Application for Planning Permission for Works or Extension to a Dwelling

Development: Side extension to bungalow and internal alterations.
Re roofing with standing seam metal roof and additional insulation.
Location: Sundance Yapton Road Barnham PO22 0BQ

EXISTING FRONT (NORTH) ELEVATION SCALE 1:100 @ A1

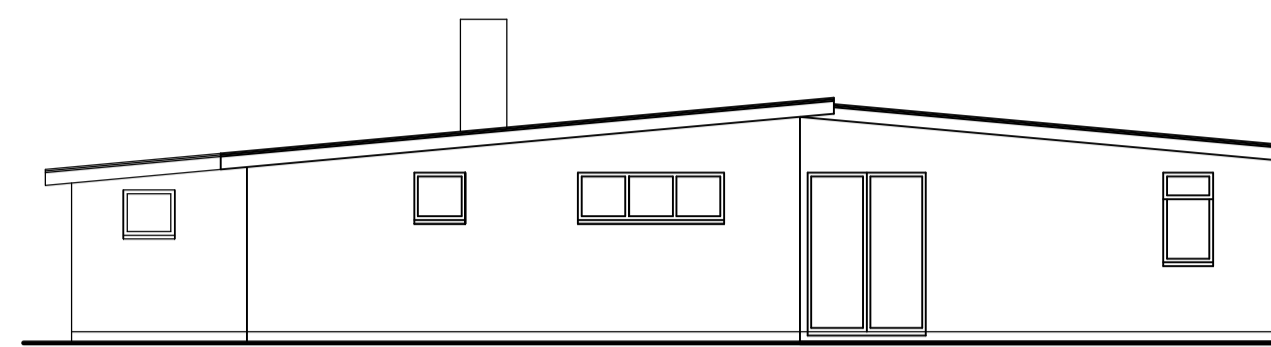
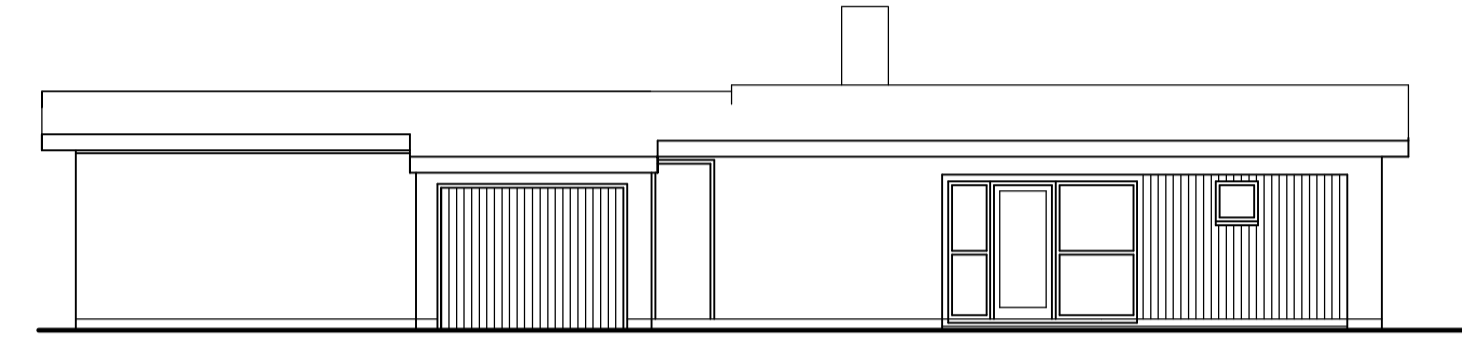
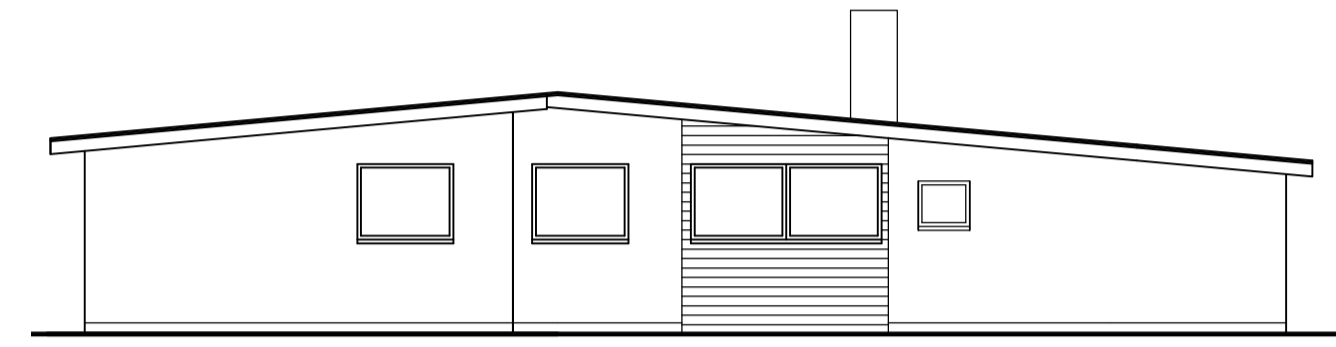
Existing Elevations

The existing front elevation has been labelled as rear, please review and amend.

SITE PLAN  
SCALE 1:500

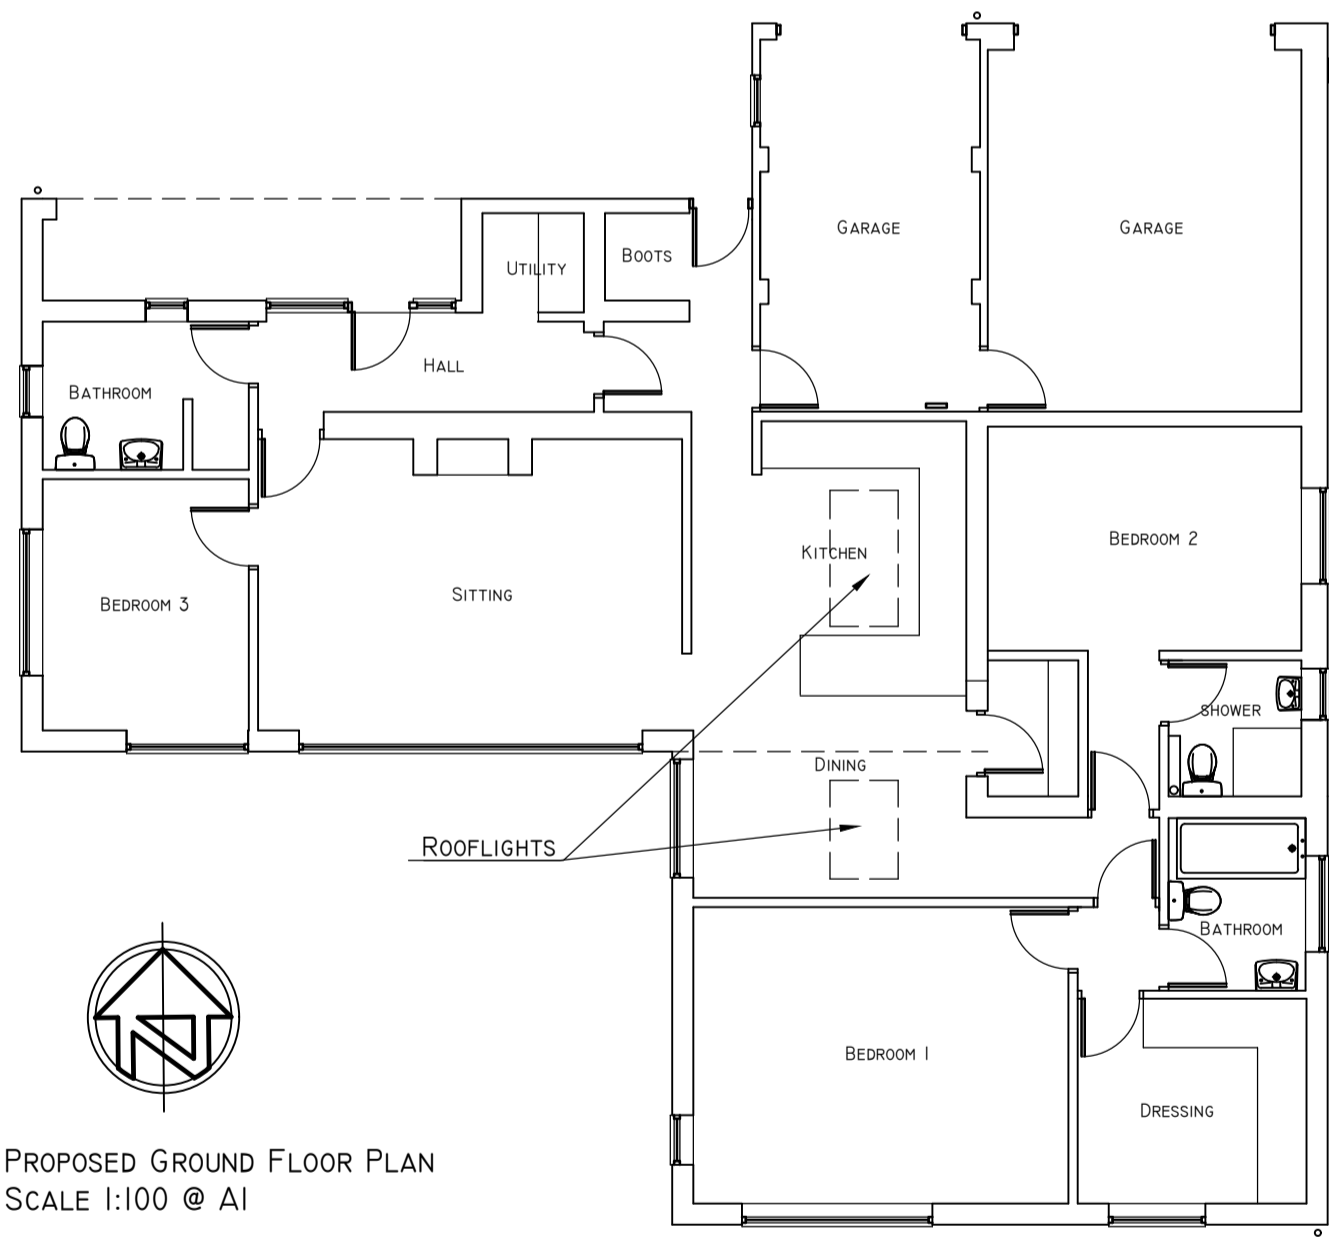
Block Plan

You are required to have dimensions from the proposed extension(s) to all site boundaries. Please amend.
